**WELWYN HATFIELD BOROUGH COUNCIL
EXECUTIVE DIRECTOR - PLANNING, PUBLIC PROTECTION AND GOVERNANCE**

DELEGATED APPLICATION

Application No: 6/2016/2654/HOUSE
Location: 35 Kentish Lane Brookmans Park Hatfield AL9 6NG
Proposal: Erection of new boundary wall & railings to match existing gates after removal of Leylandii hedge
Officer: Mrs J Pagdin

Recommendation: Granted

Drg. No  
774 / 05A

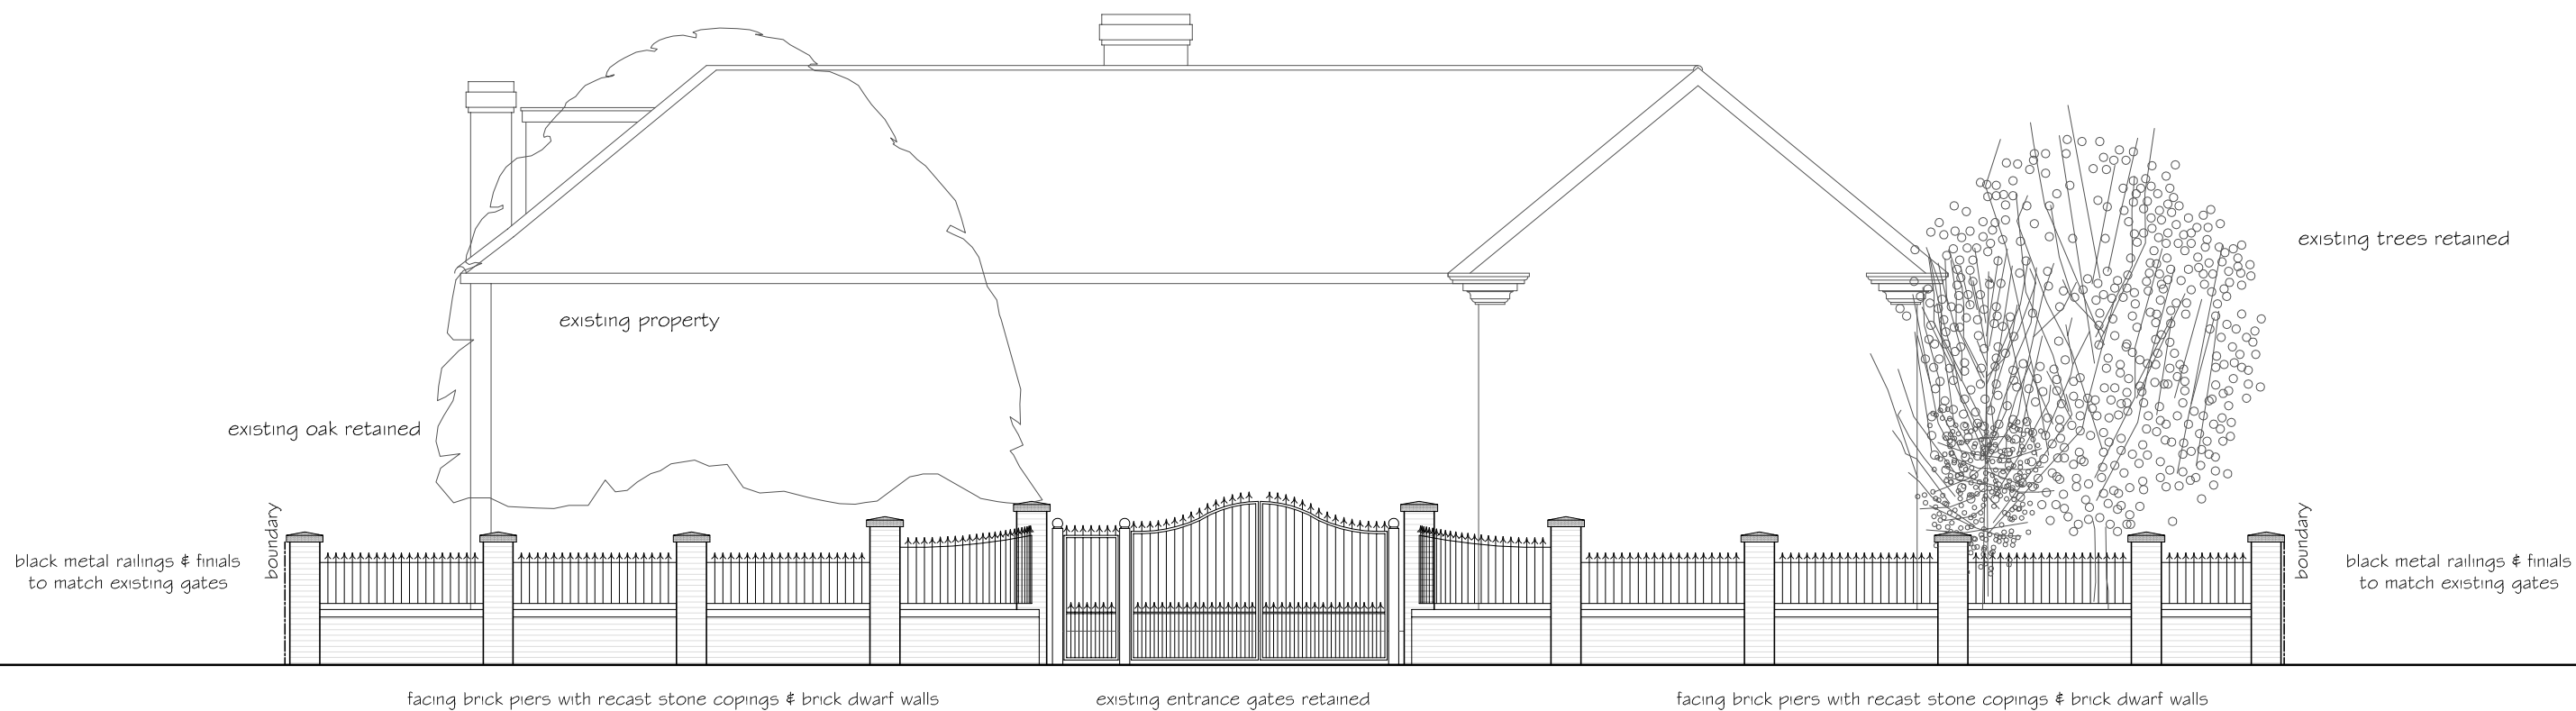
The proposed wall and railings would be 1.6m high with 2m piers; lower than the existing hedge and, consequently, would not adversely impact on the openness of the Green Belt in this location. They would be set back 1-2m from the roadway behind the grass verge and not be unduly prominent in the street-scene

The gate piers and walls would be more solid structures. However the gaps between the piers would be approximately 2.4m wide allowing views into the site. Consequently, they would not significantly reduce views into the site or significantly affect the openness of the Green Belt in this location.

<p>copings on the piers.</p> <p>On the opposite side of the road the land is open Green Belt in agricultural use and slopes down to the east. The character of the street scene is typified by informal verdant boundary treatments comprising dense planting alone or in front of low walls that allow views into the properties. Where there are gates these are low or railings that allow views into the sites beyond. The character is, therefore, open and wooded and any hard or solid materials are softened by planting.</p> <p>The proposed brick walls and railings would not be out of keeping with the material of front boundary treatments used in the near vicinity. The amended proposal now includes the installation of a replacement hedge behind the in front of the fence (but not on the highway verge) to soften it and to maintain the rural appearance of the road.</p> <p>The combined proposals for the wall, railings, retained gates and landscaping are considered to maintain the openness of the Green Belt in this location and to achieve a softened boundary treatment appropriate to the character of the road. They are, therefore, considered to be appropriate in the Green Belt in accordance with the Green Belt Policies of the NPPF (2012) and Policies GBSP2, RA3, D1 and D2 of the Welwyn Hatfield District Pan 2005.</p> <p>The walls and railings, while they would not be rural in character, would be modest in scale, set back from the road and partly softened by landscaping. The scale of the piers and walls is modest and not significantly affect the openness of the green belt in this location. However, the colour of the bricks would need to be appropriate to the setting. It is recommended that a condition is imposed requiring submission of sample bricks prior to commencement of development.</p>

1. No development shall take place until samples of the materials to be used in the construction of the wall hereby granted have been submitted to and approved in writing by the Local Planning Authority. The development shall be implemented using the approved materials and subsequently, the approved materials shall not be changed.
